PORTLAND MAINE

September 8, 2008

RE: 461 Woodford Street – 176 B003 – R-5 – illegal deck – permit #08-0249

## 459-461 Woodford

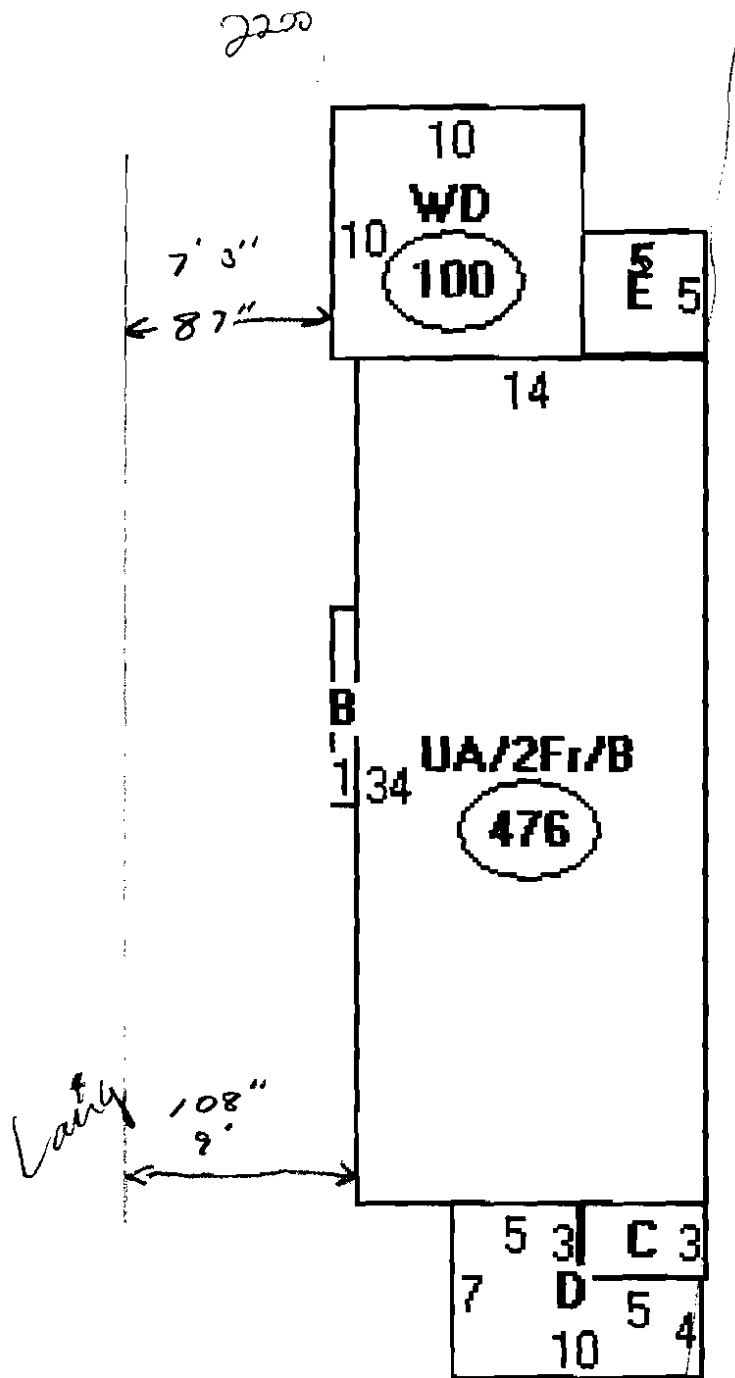
I called you last Friday, September 5, 2008 to follow up on your application to add a roof to the rear porch at your house at 461 Woodford Street. I wrote you an initial letter about this application on March 20, 2008 informing you that the existing deck was not permitted and that it did not meet the required side setback of eight feet. I also told you that you could not permit the deck after the fact because section 14-388 did not allow you to enlarge your building if you did not meet the required land area per dwelling unit. You had thirty days to appeal my decision or remove the deck.

I did not hear from you after that and the thirty-day period to appeal ended on April 19, 2008. When I called you last Friday, you told me that the deck was still there. You also asked me about whether section 14-388 of the ordinance had been changed. At this point section 14-388 is part of the ordinance, so you can't apply to permit the existing deck. It must be removed within fourteen days to bring your property into compliance. An inspection has been scheduled for Monday, September 22, 2008. If the deck is still there, we will turn the matter over to our Corporation Counsel, and they may begin legal proceedings to bring the property into compliance. As I said before, you might be able to rebuild the back stairs that existed before the deck was built, but we need a picture of the old foundation and the dimensions.
